**Town & Country Planning Act 1990 (as amended)
Town & country Planning (Development Management Procedure) (England) Order 2010 (as amended)**

Application for Planning Permission for Works or Extension to a Dwelling

Development Remove existing single storey garage and replace with 2-storey extension.

Location 5 Denham Close Bognor Regis

DRAWING TITLE:  
**PLANNING**  
Location & Block Plan: proposed Floor  
Plans: Proposed Elevations.

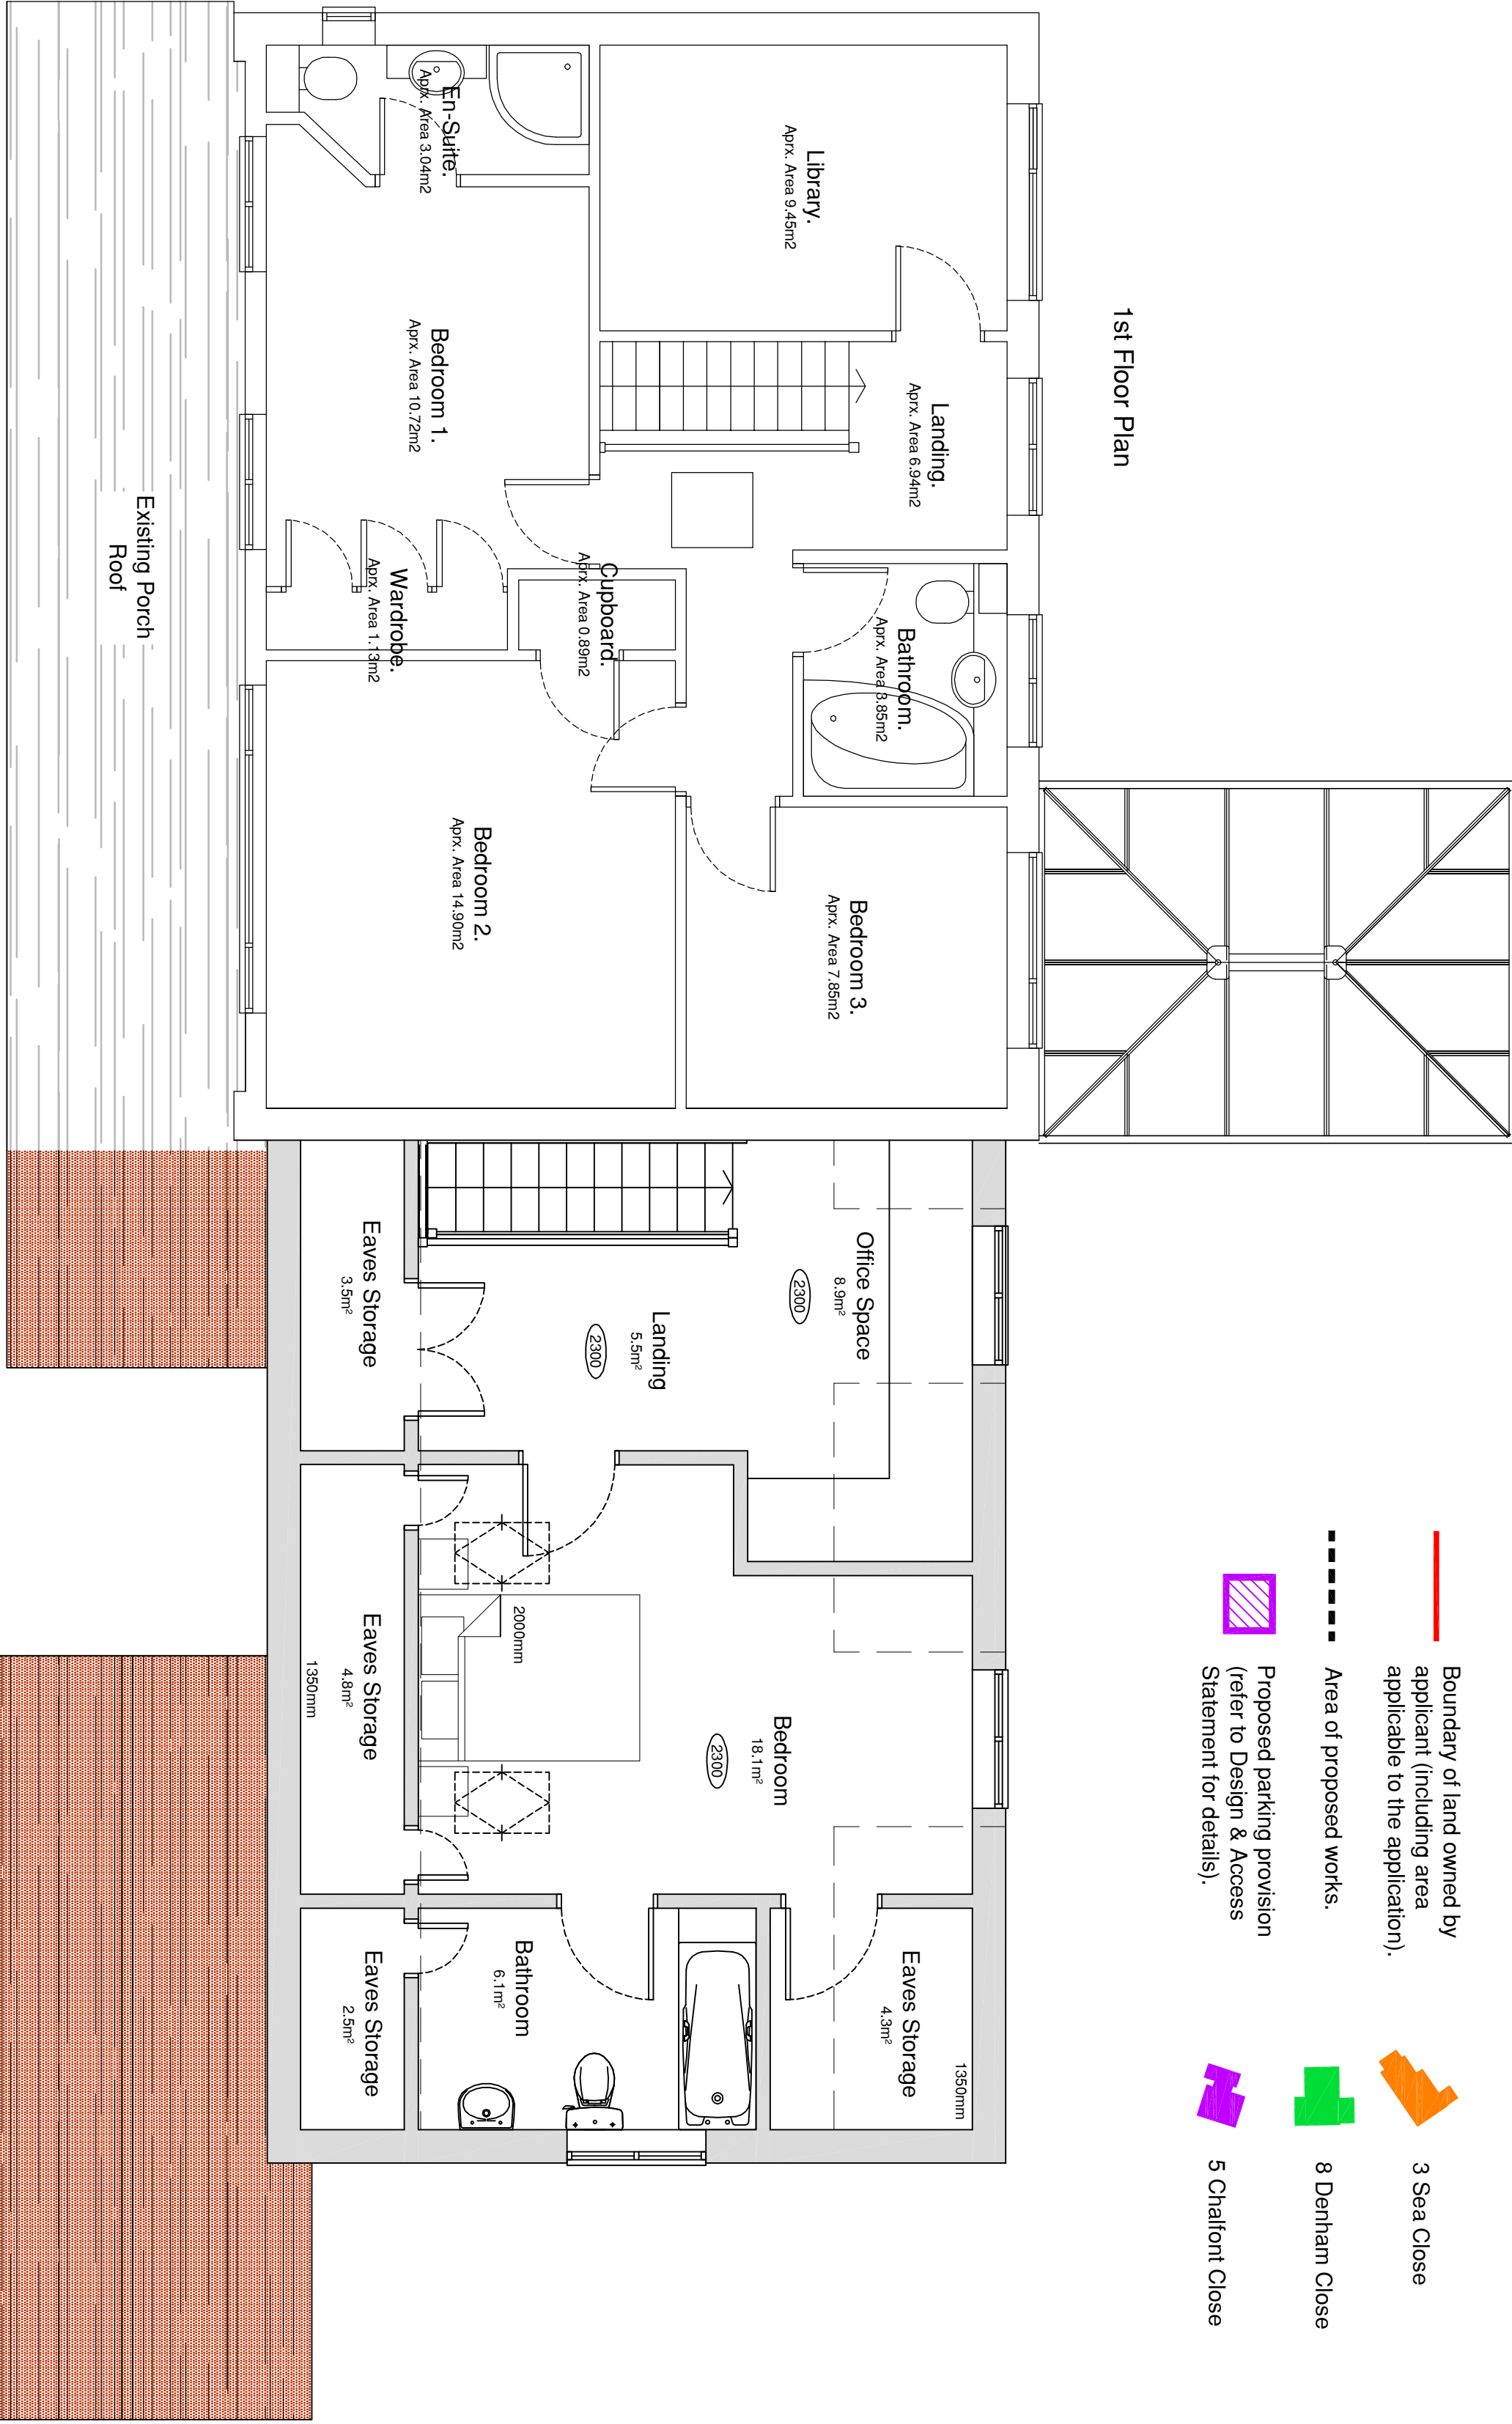
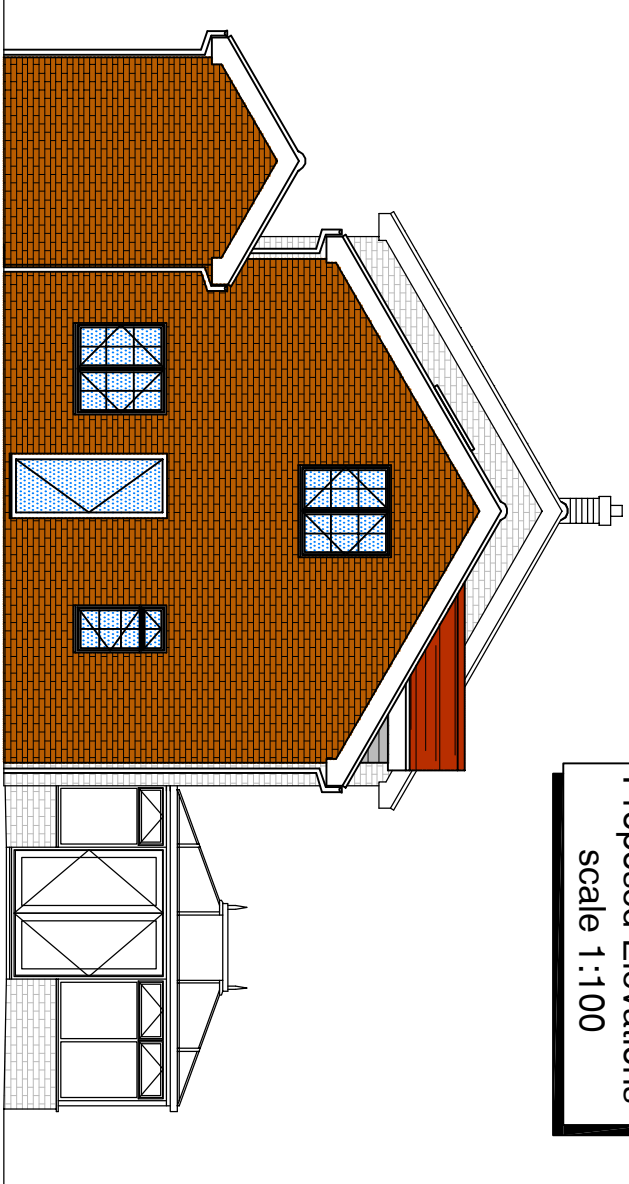
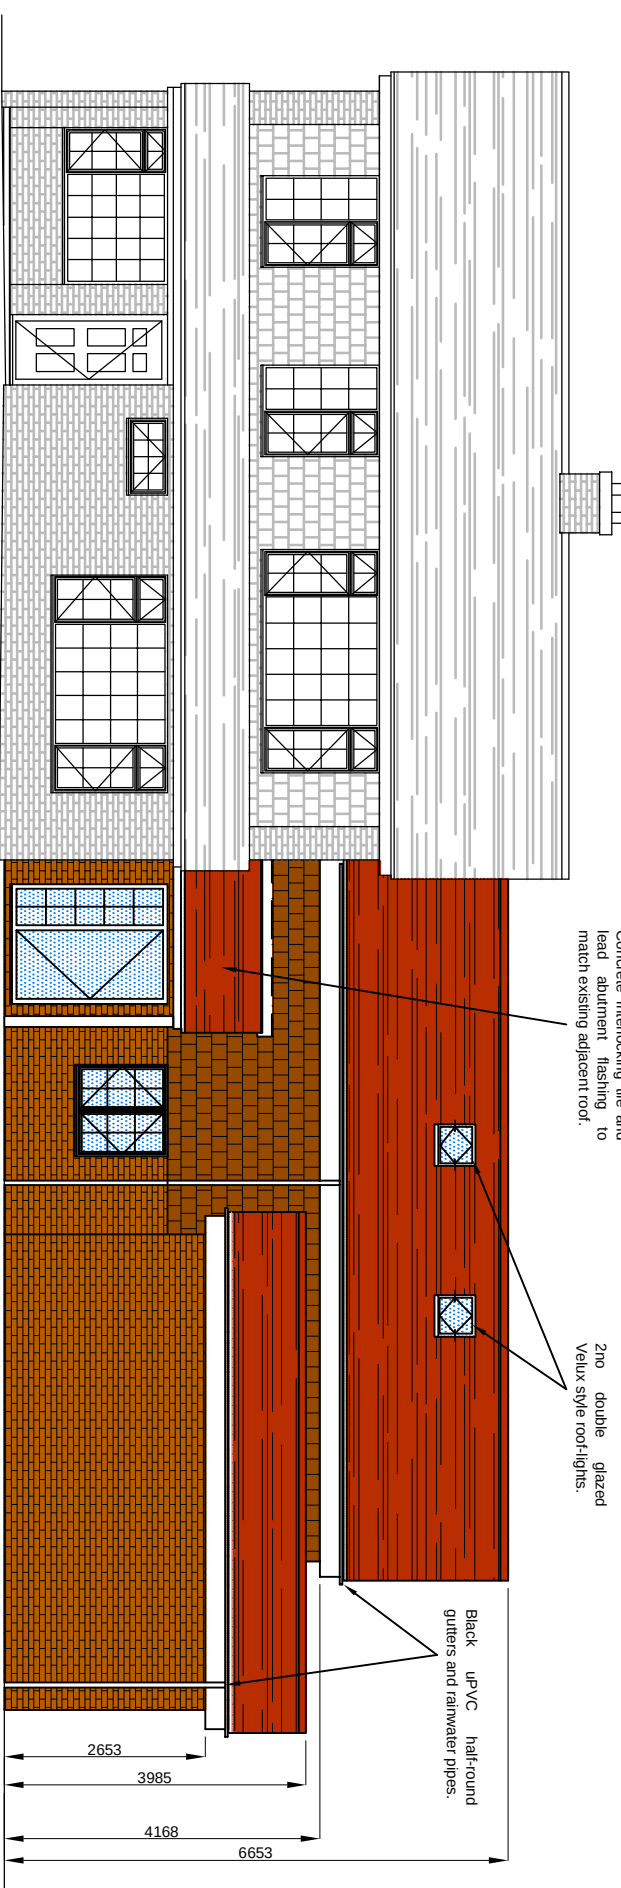
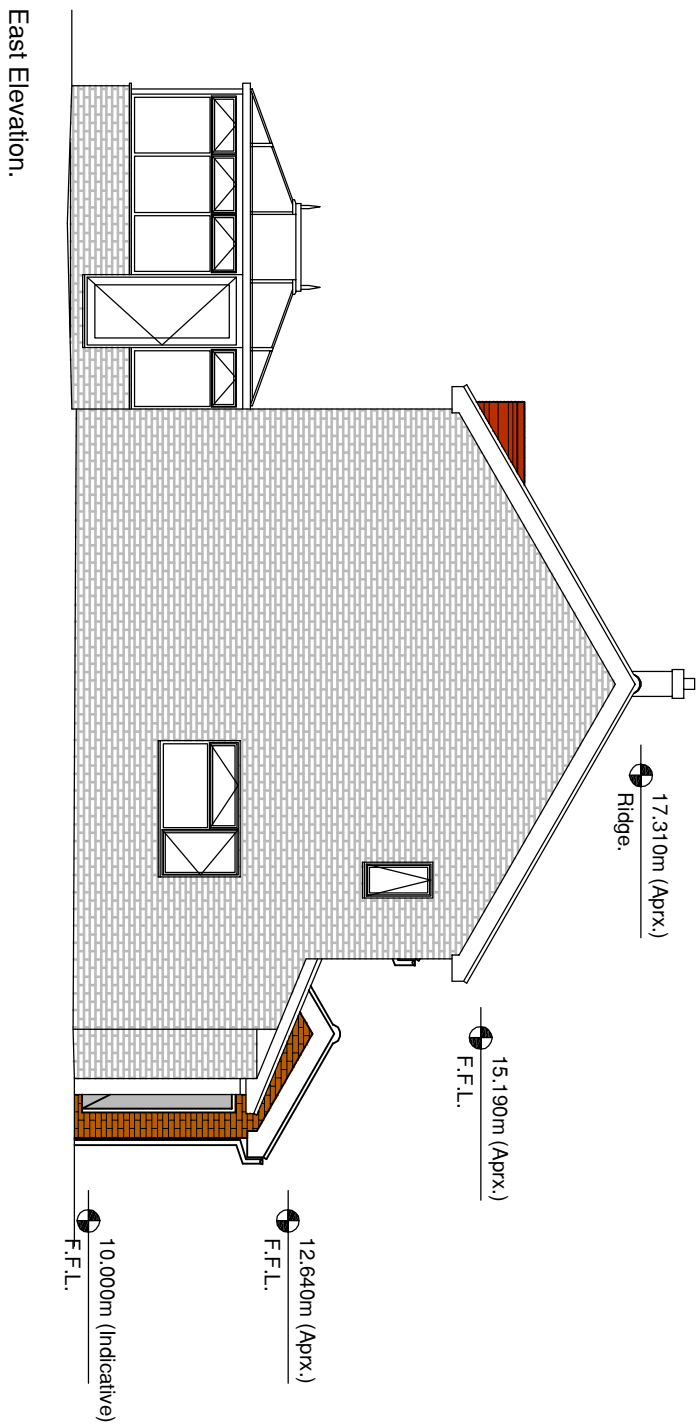
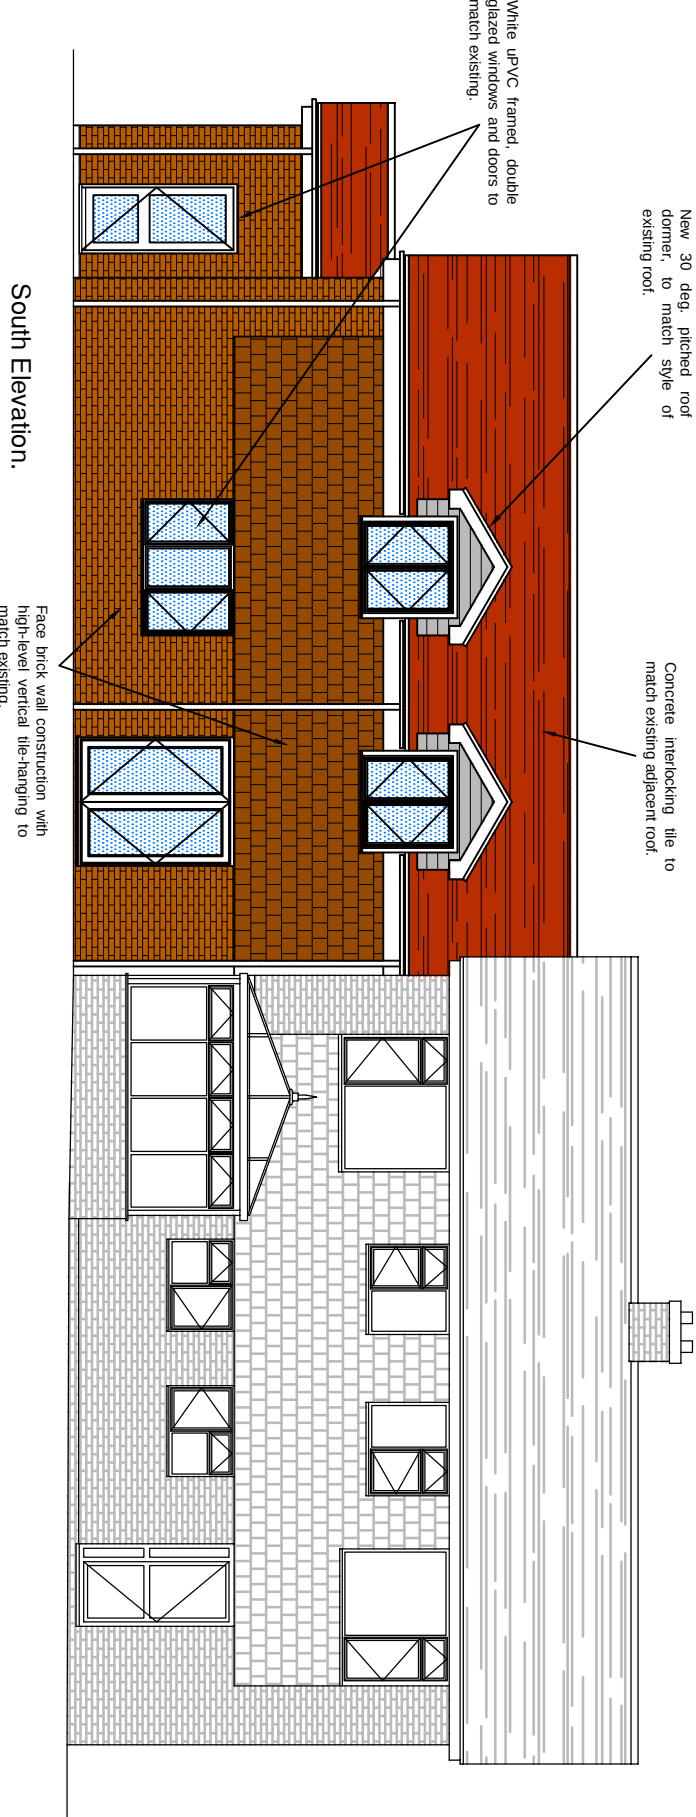
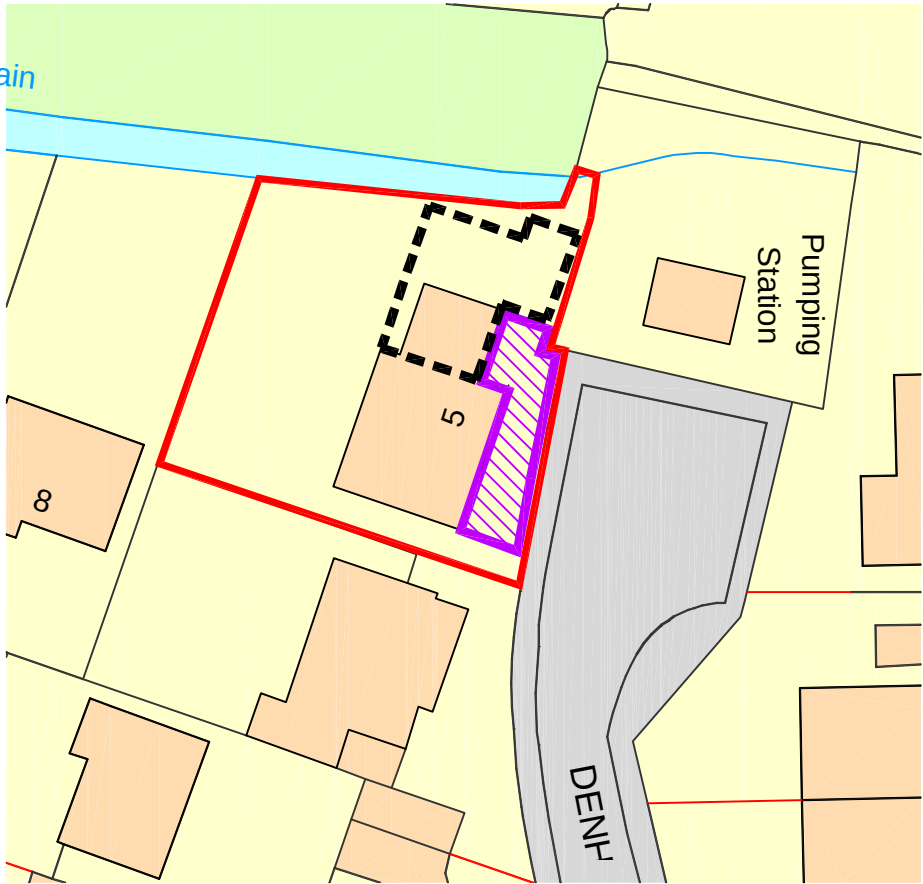
Please submit 1 electronic or 3 paper copies of a location plan at a scale of 1:1250 or 1:2500 for rural areas. Further details of what must be included on the plan can be found in the National Validation Requirements. Please edge the site in red and nothing in blue.

Please submit 1 electronic or 3 paper copies of a block/site plan at a scale of 1:500 or 1:200. Further details of what must be included on the plan can be found in the National Validation Requirements. Please only highlight the works proposed and provide measurements of the proposed work to the boundaries of the site on the Block plan at a scale of 1:500.

Please label the proposed elevations as North, South, East and West as appropriate.
